**Consultation Response from KC,
Lead Local Flood Authority**

2022/93631 20, Kelloe Street, Cleckheaton, BD19 4EN

Demolition of existing building and erection of apartment block

Date Responded: 26th May 2023

Prop. Site
1 : 200

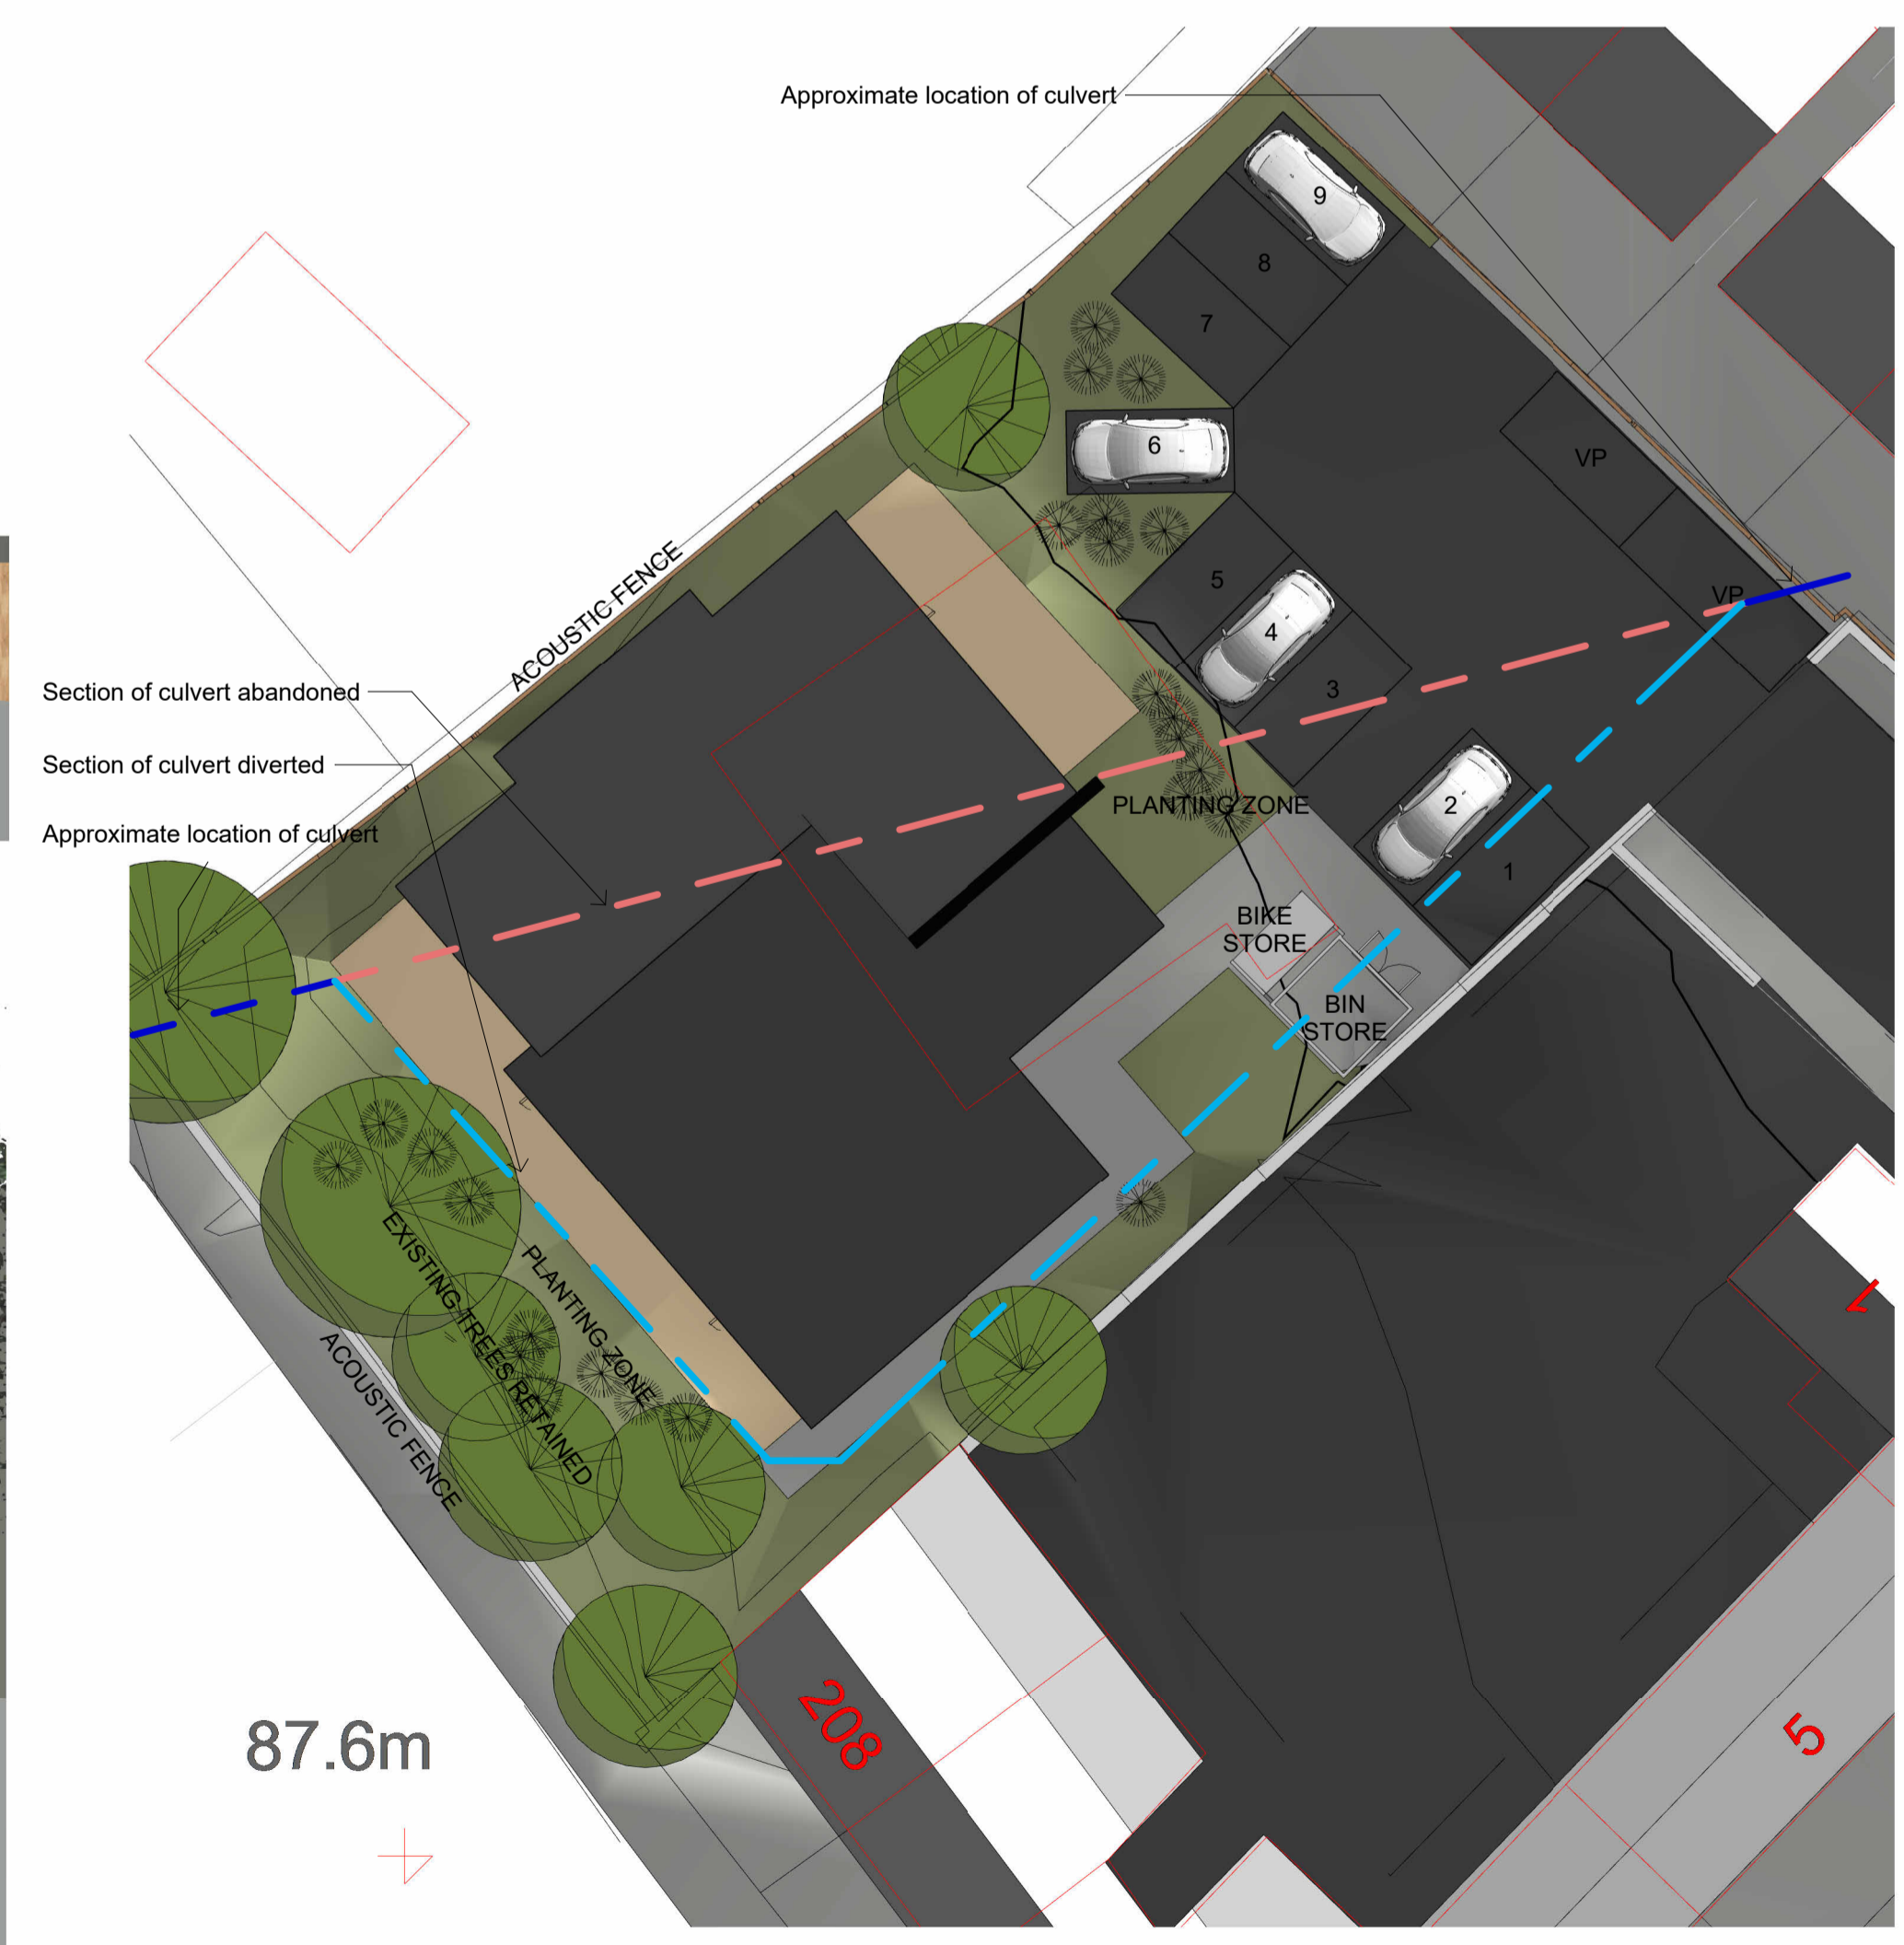
Kirklees Flood Management & Drainage OBJECTS to this application as a significant culvert crosses the site. Its exact location is assumed and therefore a diversion promoted is also 'assumed feasible' by the applicant. Such a diversion incorporating severe angles will have significant effect on the performance of the watercourse and raise the risk of blockages.

Any promoted building work should work around this constraint or improve flows within site and not vice versa.

We therefore suggest that the culvert is located, accurately depicted, and surveyed for size, depth, and condition, before any further changes to the application are submitted.
